Online Comment

Application H06-0726-25
Location Rozel Marsh Road Gedney Drove End PE12 9PL
Proposal Demolition of existing dwelling and erection of 2 dwellings

Name Parish Clerk
Address Gedney Parish Council

Date Submitted 12-11-25
For/Against Objections

## FRONT ELEVATION

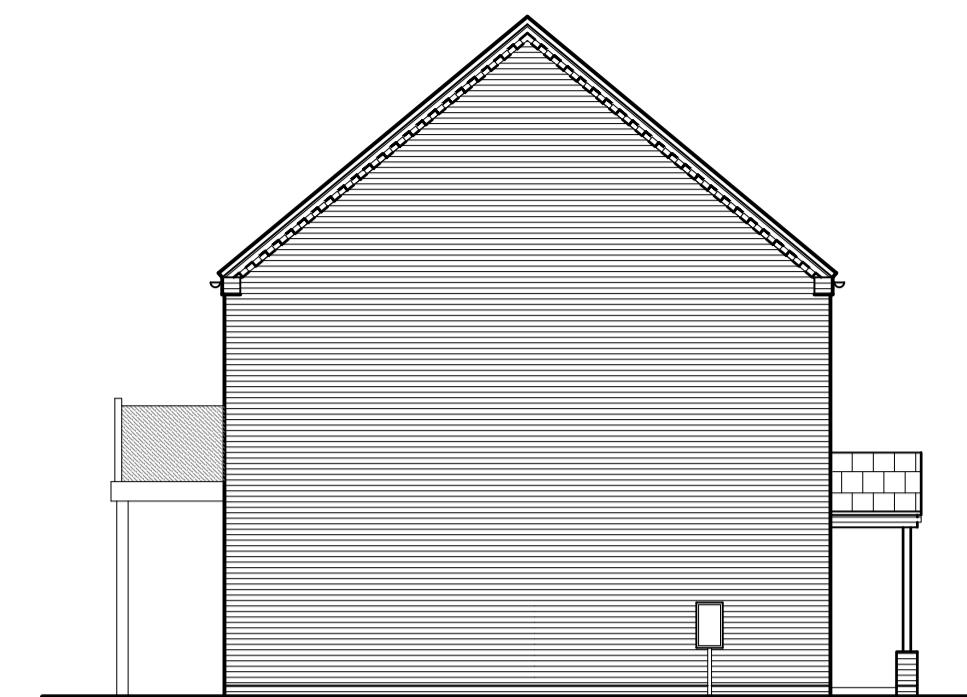
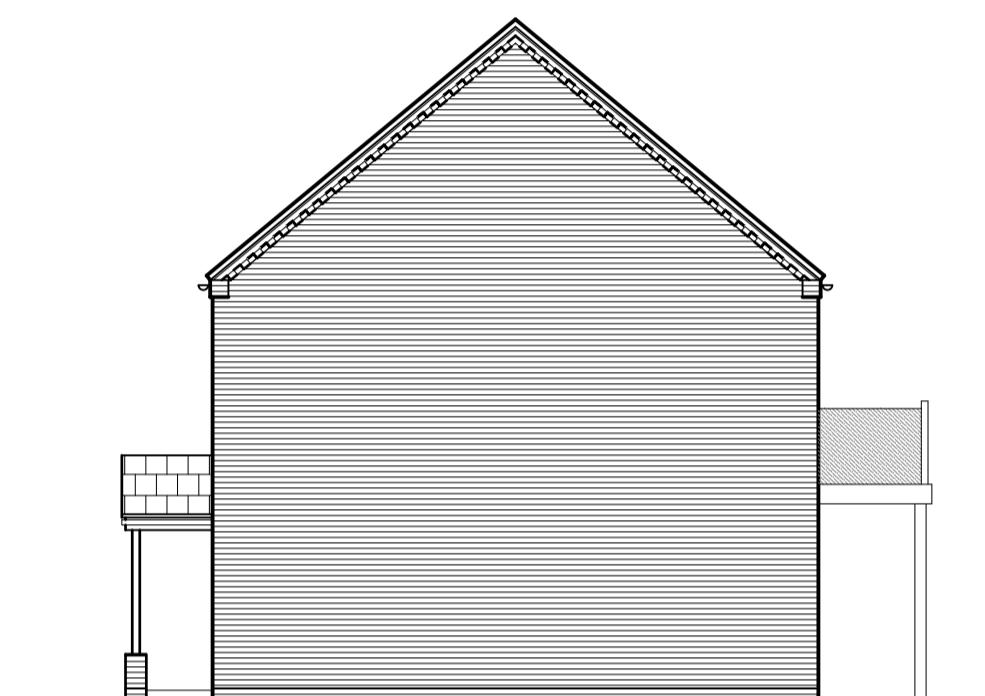
Council object to this application on the following grounds:
There is no height of the buildings shown on the elevation plans
There is a good possibility of asbestos in the existing building for demolition due to its construction and age (not mentioned in application)
Over development of the site.
Due to height and elevation of plot blocking of light to single story properties opposite
